From: Nolan, Chris <Chris.Nolan@lancashire.gov.uk>
Sent: 29 June 2017 11:28
To: Stephen Kilmartin; planning
Cc: LHS Customer Service
Subject: D3.2017.0422 - Rear of 30 Beverley Drive Clitheroe BB7 1HY

With regard to the application D3.2017.0422 for the development of three dwellings at the rear of 30 Beverley Drive to be accessed by a new vehicle access from Primrose Road the speed survey has indicated 85 percentile speeds of 28.8mph for westbound traffic and 30.8mph eastbound traffic. It is these speeds that are used to indicate the safe sight lines that would be required for the new access. I would be looking for safe sight lines of 40m to the east of the centre line of the access point and 44m to the west of the centreline of the access point.

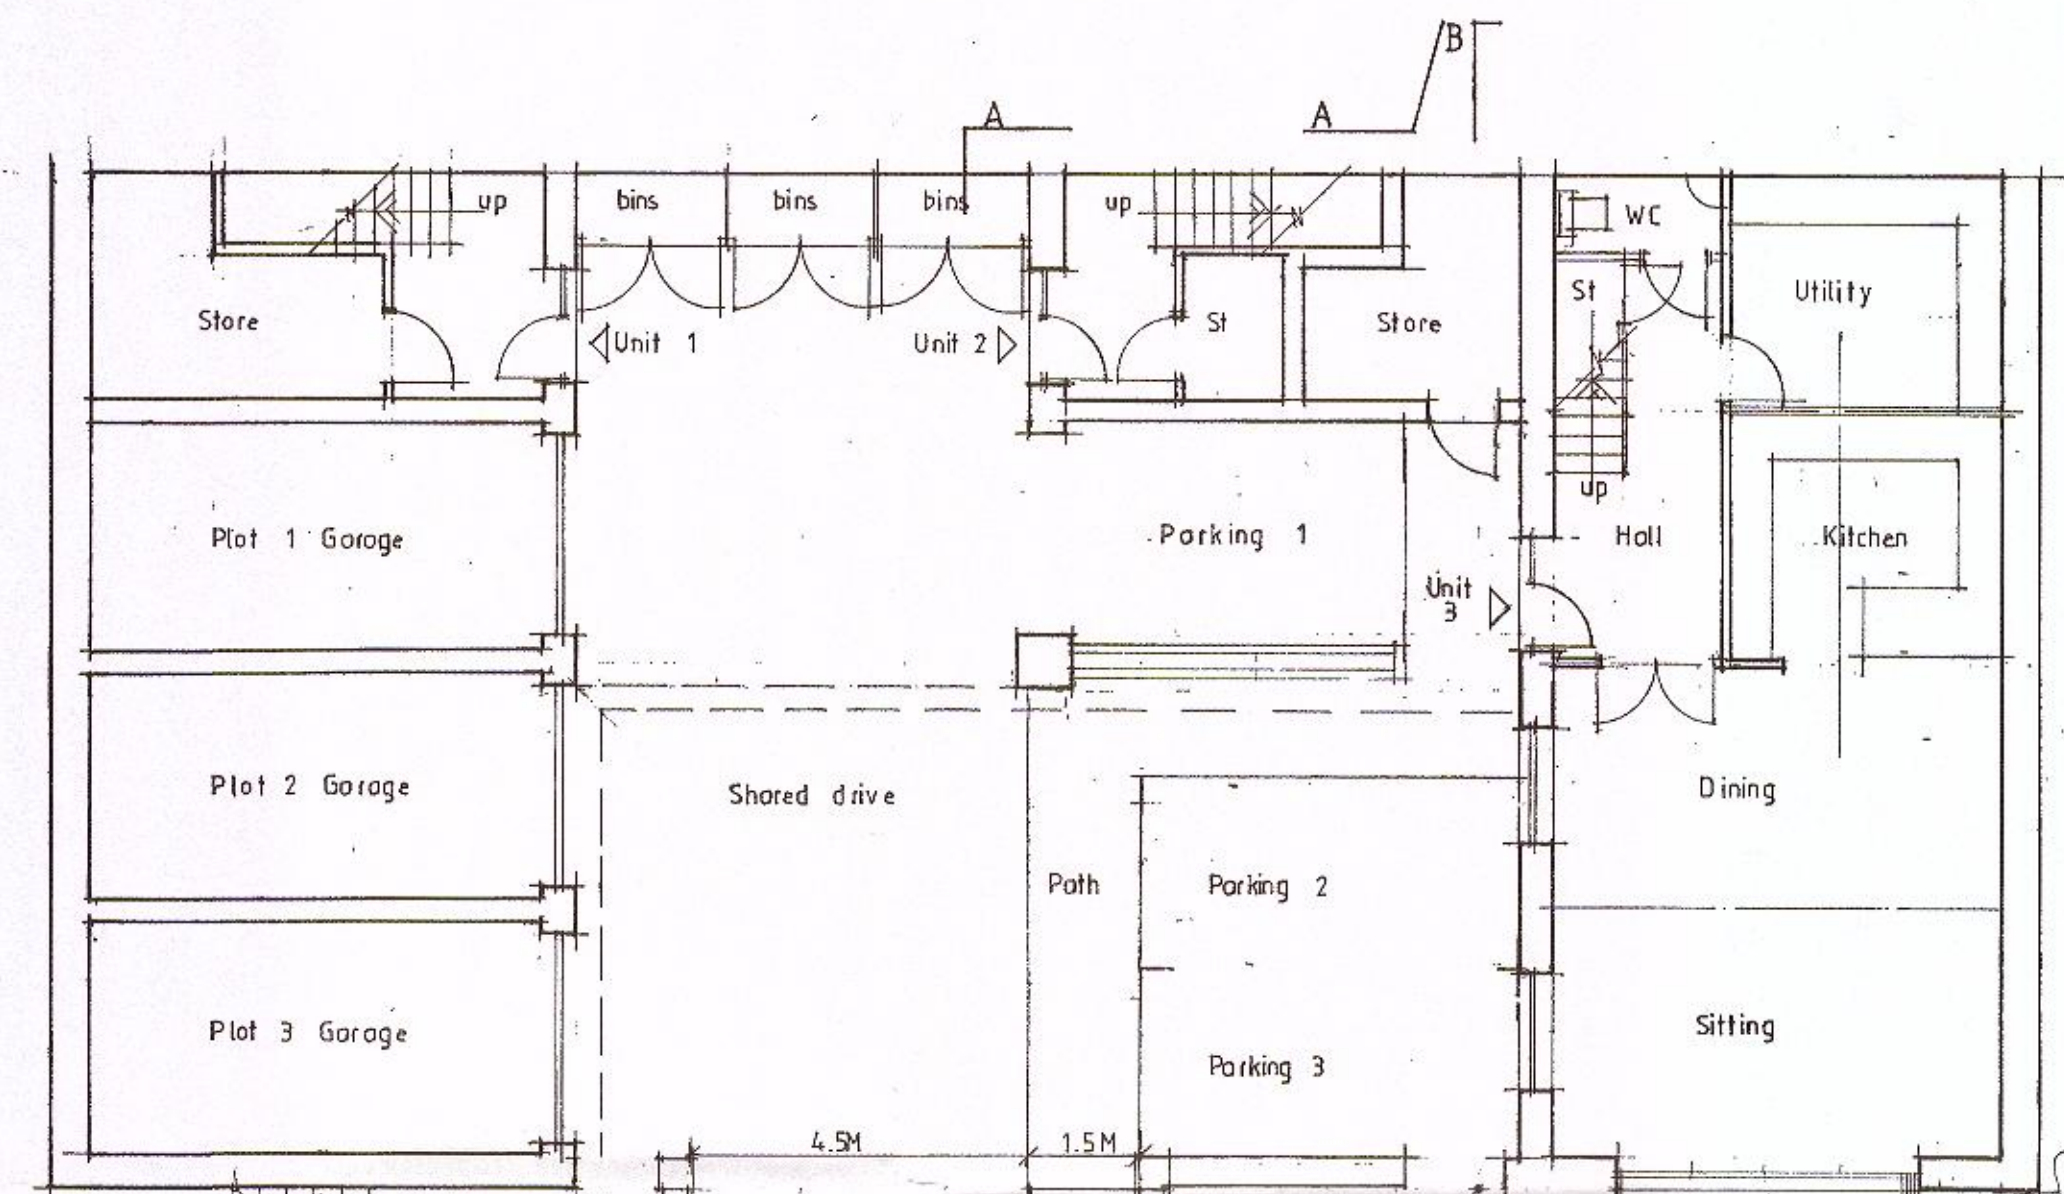
The present plans submitted indicate sightlines of 26.5m to the east and 32m to the west. These drawings do not indicate that the sight lines will be preserved as the present retaining walls are above 1m high and the plans also indicate that it is proposed to include some vegetation that may be allowed to grow to a height that would obscure the present inadequate provision. I would require that the developer produces drawings indicating sufficient sight lines to be able to meet the requirements as stated above. The sightlines would need to be preserved in perpetuity by being kept free of all buildings, structures or erections, whether above or below the surface of the land, excepting gates, fences or walls not exceeding a height of 1m. I would also need to be sure that any vegetation would not exceed 1m above the level of the carriageway of Primrose Road.

This information is in addition to my previous comments as the requirements could not be quantified at that time due a lack of data regarding the actual running speed of traffic on Primrose Road. I would still be looking for Information to indicate that the parking provision will be set to ensure that all vehicles can enter and leave the highway using forward gears. This is especially important because of the difficulties on Primrose Road.

I would also ask that development included A footway for the full frontage of the site to assist with pedestrian safety and sightlines for traffic entering and leaving the site.

In the light of the above concerns I would have to recommend that the application be refused on the grounds that the applicant has failed to demonstrate that the development can be safely accessed and that vehicles would be able to enter and leave in forward gear. Should your Council be minded to approve this application then I would request that the following conditions and notes are attached to any permissions.

5. Notwithstanding the provisions of the Town and Country Planning (General Permitted Development) Order 1995 there shall not at any time in connection with the development hereby permitted be erected or planted or allowed to remain upon the land hereinafter defined any building, wall, fence, hedge, tree, shrub or other device over 1m above road level. The visibility splay to be the subject of this condition shall be that land in front of a line drawn from a point 2.4m measured along the centre line of the proposed entrance from the continuation of the nearer edge of the carriageway of Primrose Road to points measured 40m in a easterly direction and 44m in a westerly direction along the nearer edge of the carriageway of Primrose Road, from the centre line of the shared drive (add 'and shall be constructed and maintained at footway/verge level in accordance with a scheme to be agreed by the Local Planning Authority in conjunction with the Highway Authority'). Reason: To ensure adequate visibility at the street junction or site access.

9. The level of the driveway at development shall be constructed 0.150m above the crown level of the carriageway of Primrose Road. Reason: To safeguard the future reconstruction of the highway.
